APPROVED  
 Licensed building entity review  
 Permit holder responsible for  
 full compliance with the code

SEE FRAMING NOTES

James + Jean S. Bradley  
 308 West E St.  
 Sumner, NC 28389  
 910-890-9024  
 910-658-6457

PROPOSED  
ADDITION

PROPOSED
ADDITION

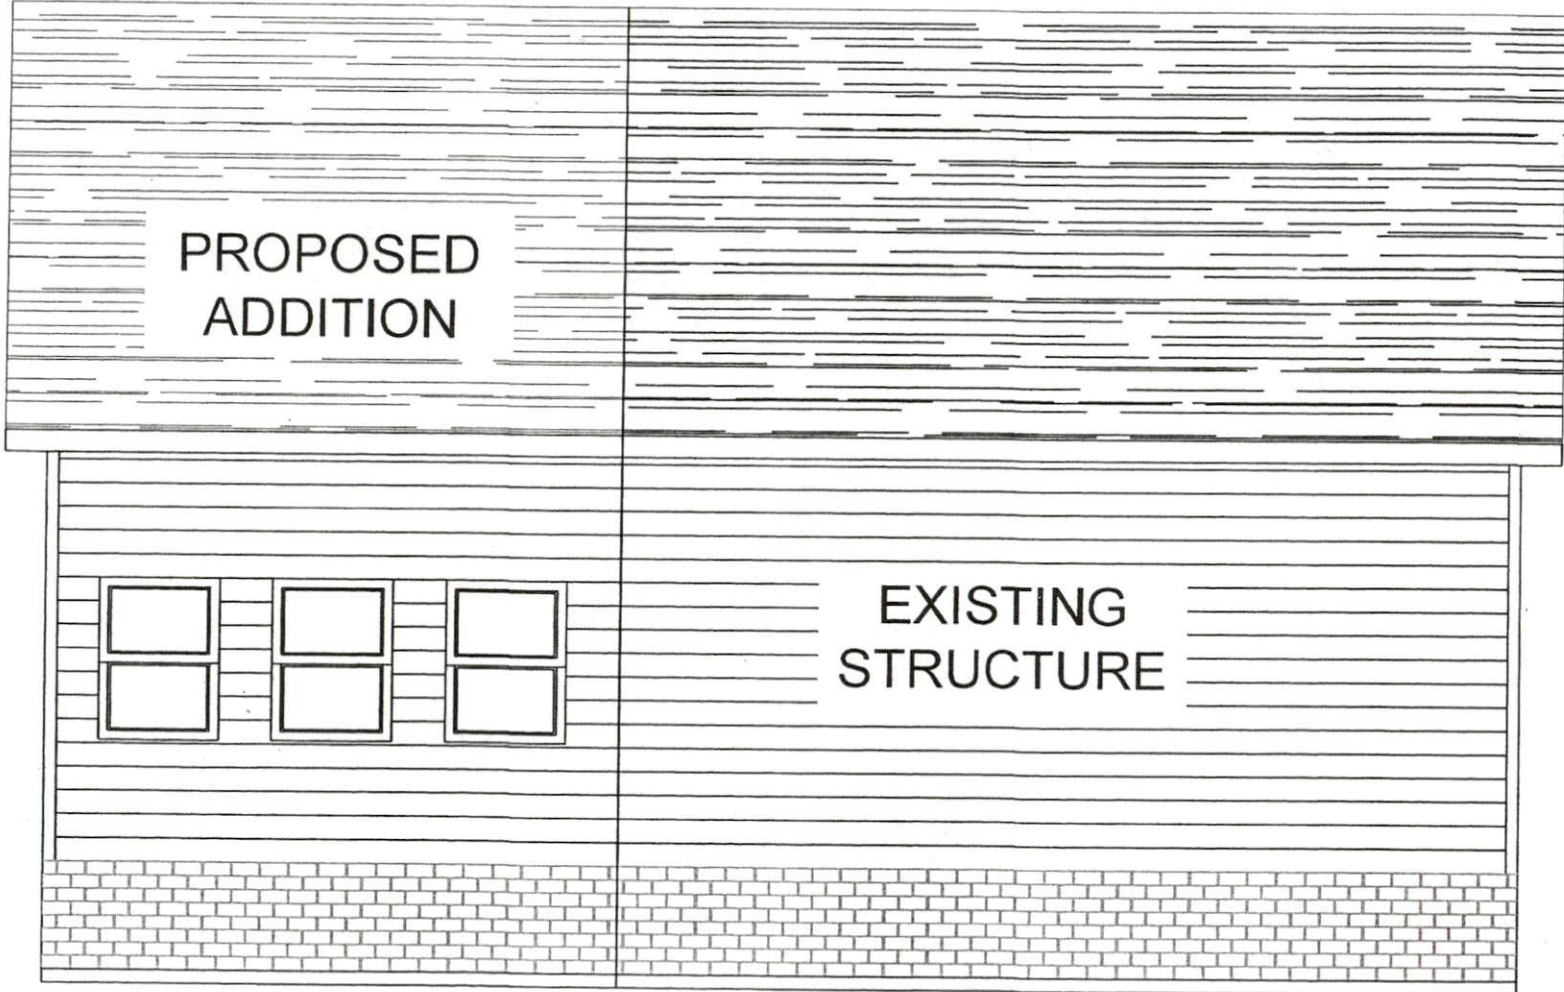
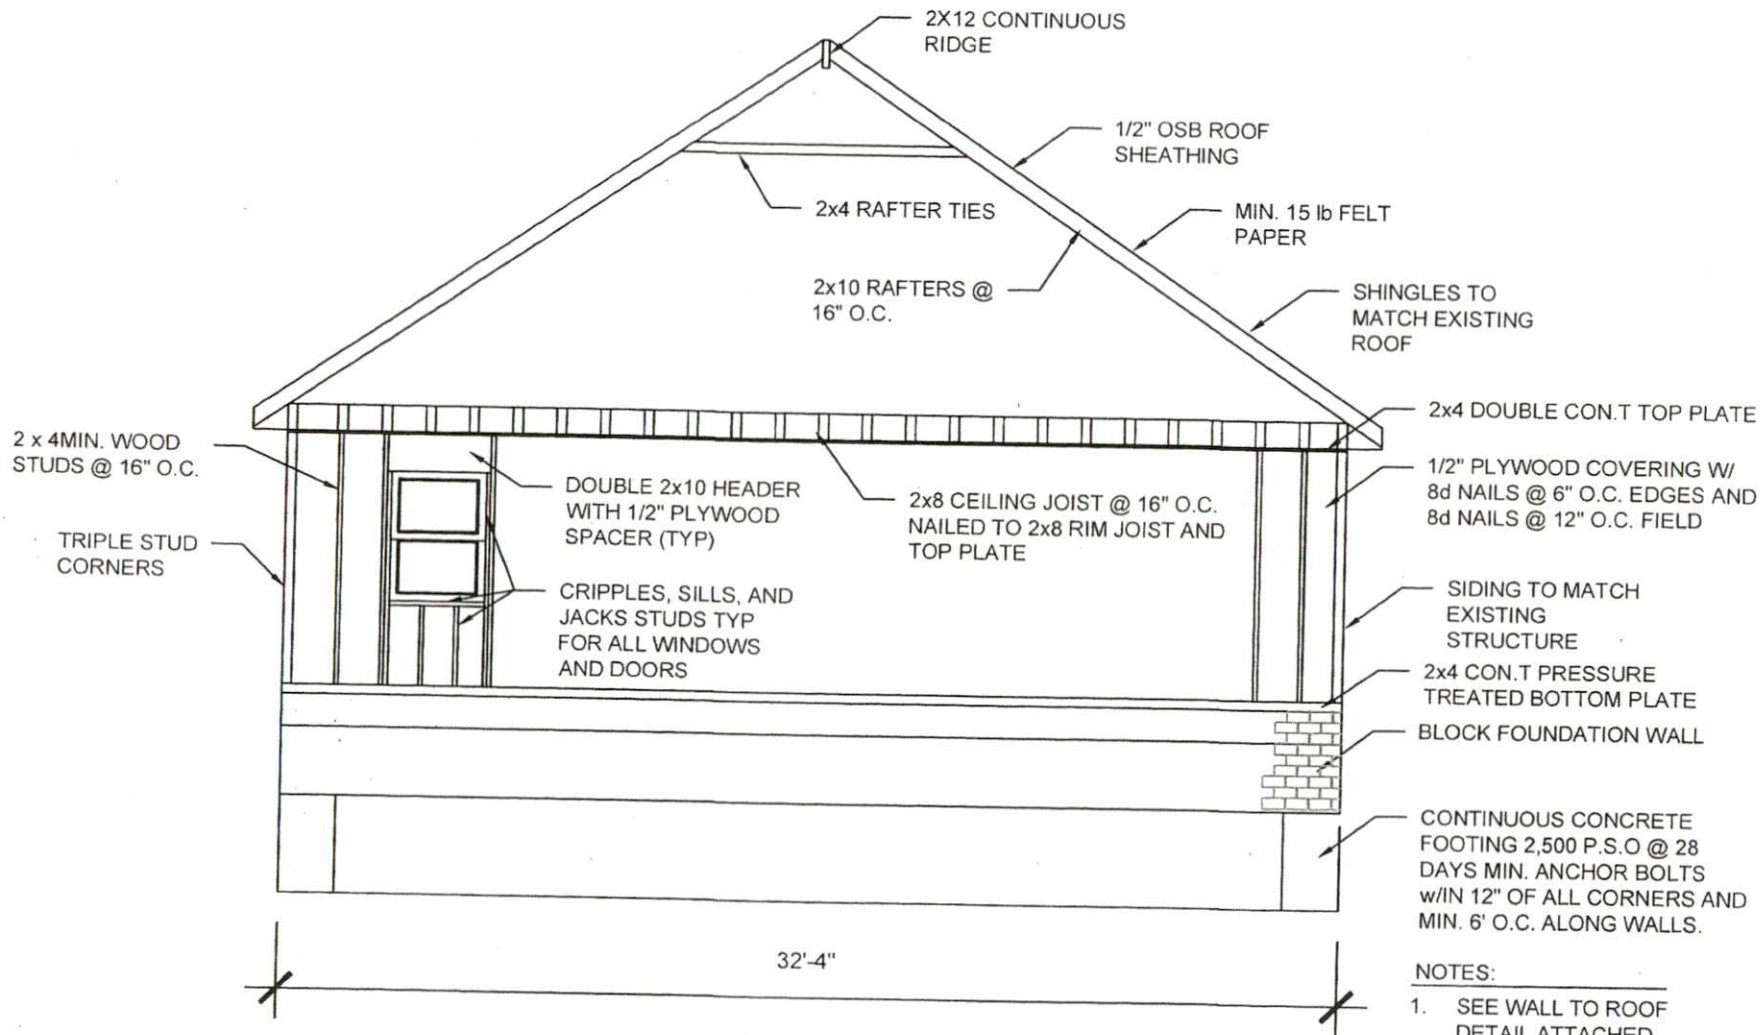
2x10 @ 16" oc min  
for this span

~~2x8~~ CONTINUOUS  
RIM JOIST

~~2x8 FLOOR JOIST~~  
@16" O.C. WITH  
BRIDGING (TYP)

WALL TO ROOF

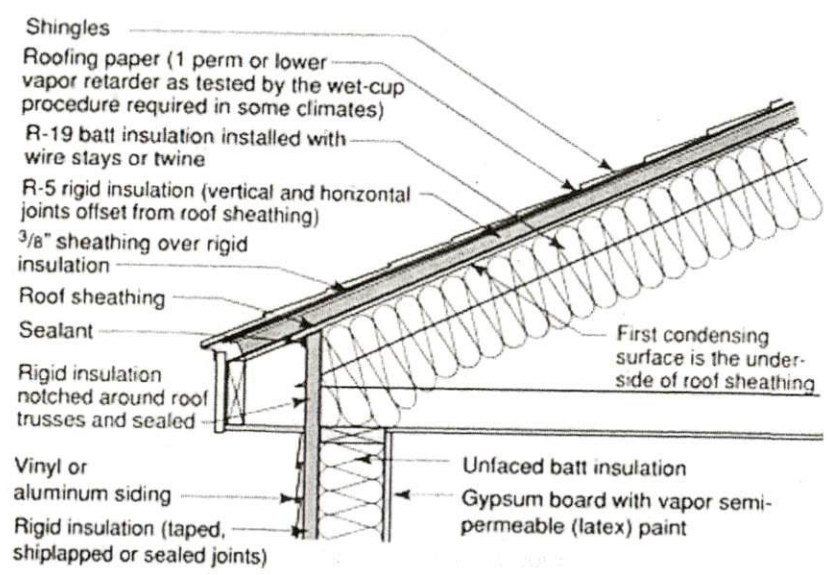
Continuous metal ties across top of ceiling to tie ceiling diaphragm to roof system. Rafters and ceiling joists shall be tied together
